From: [Johnson, Melissa](#)  
To: [Tilbury2](#)  
Cc: [Elsenaar, Marnix](#); [Hodge, Sarah](#)  
Subject: TR030003 - Tilbury2 DCO Application - Written Representations on behalf of Network Rail  
Date: 19 March 2018 11:25:28

**Application by Port of Tilbury London Limited for an Order granting Development Consent for the Proposed Port Terminal at the Former Tilbury Power Station**

**Written Representation of Network Rail Infrastructure Limited**

**Planning Inspectorate Reference: – TR030003**

PROPOSED FORT ROAD OVERBRIDGE
(WORK NO. 10) MINIMUM HEADROOM 5.3m

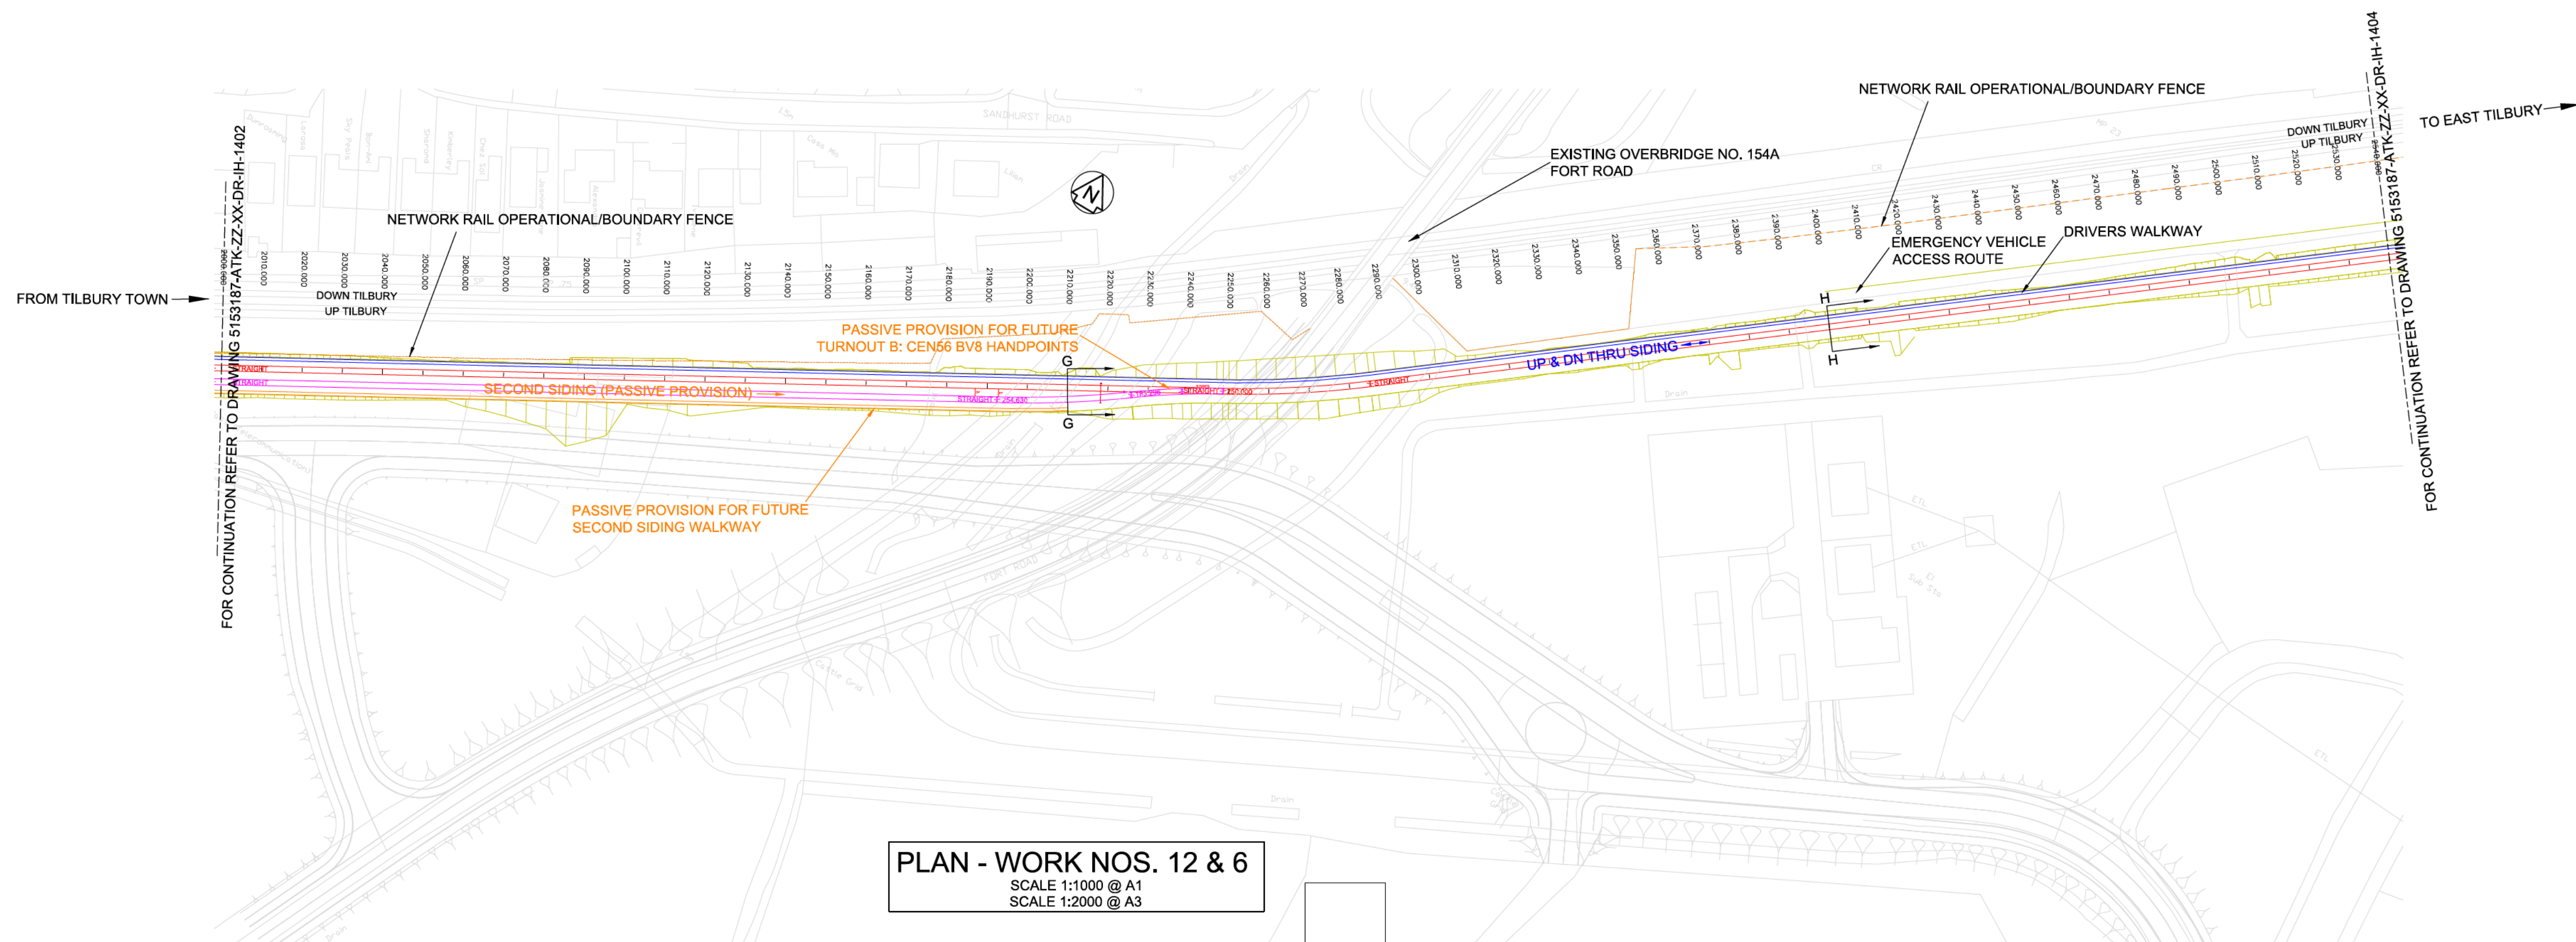
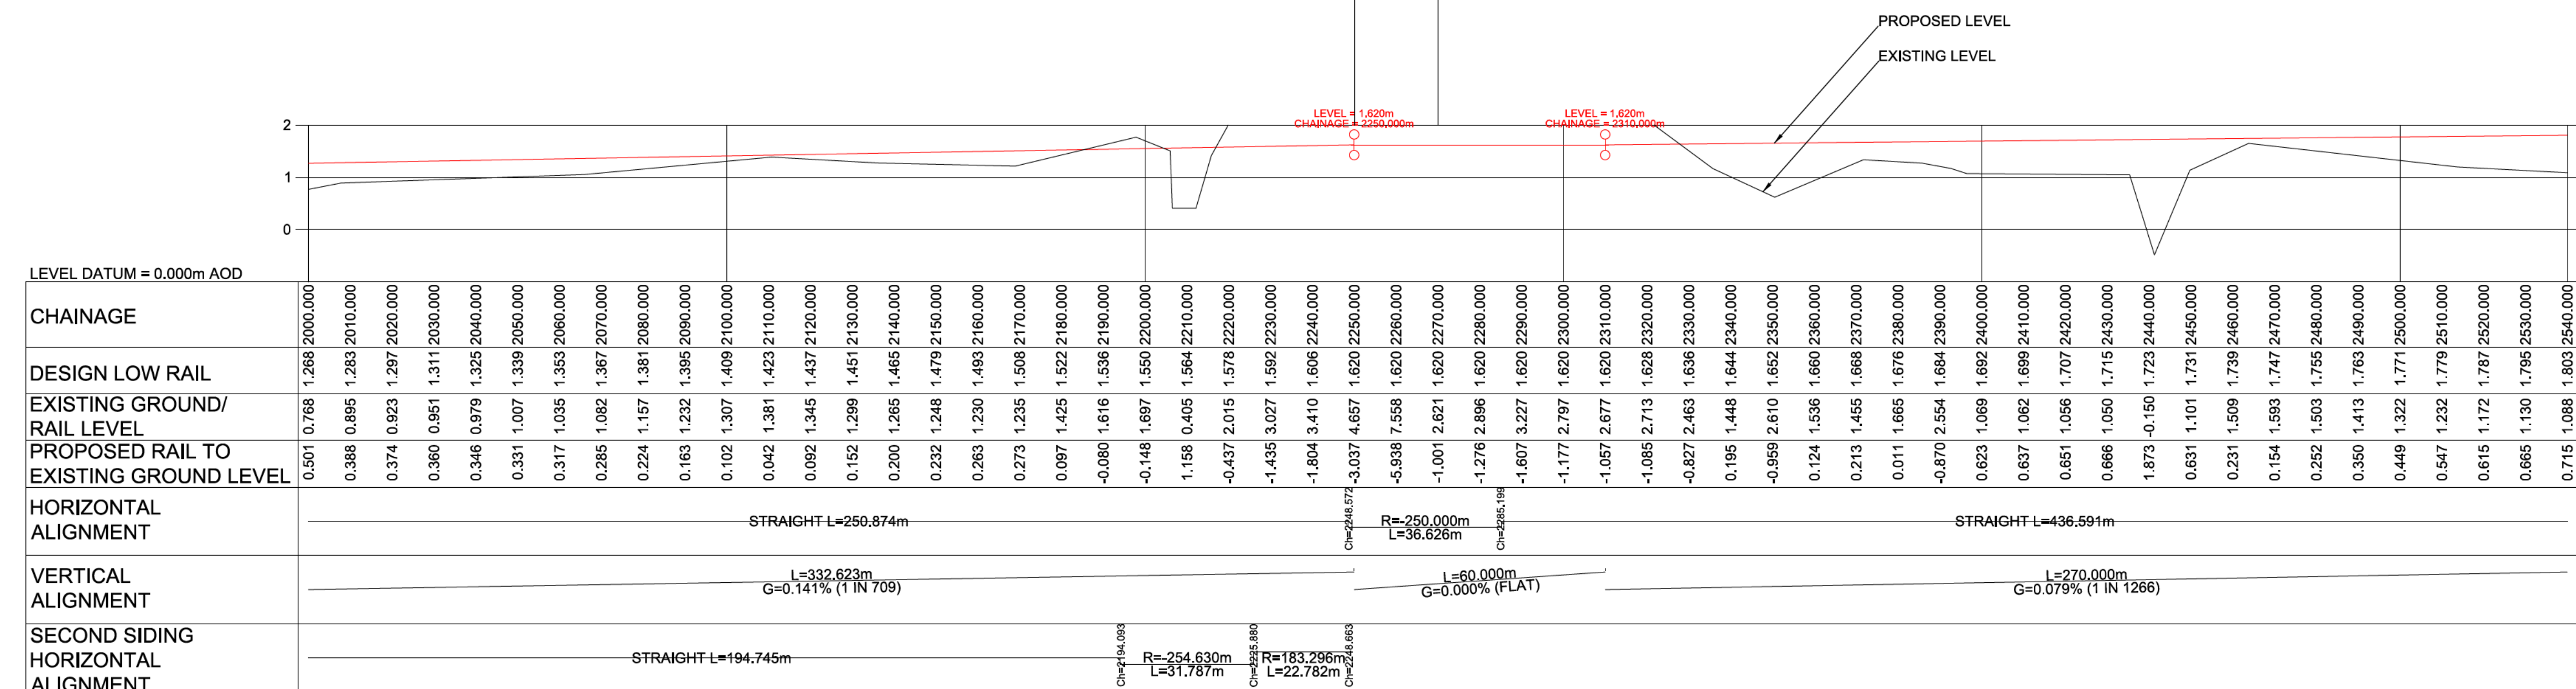
- (c) the extension of a road overbridge at Fort Road that will cross the Mainline due to potential for damage to and debris falling on the existing Mainline and the impact such works may have on the ability to maintain and expand the Mainline.
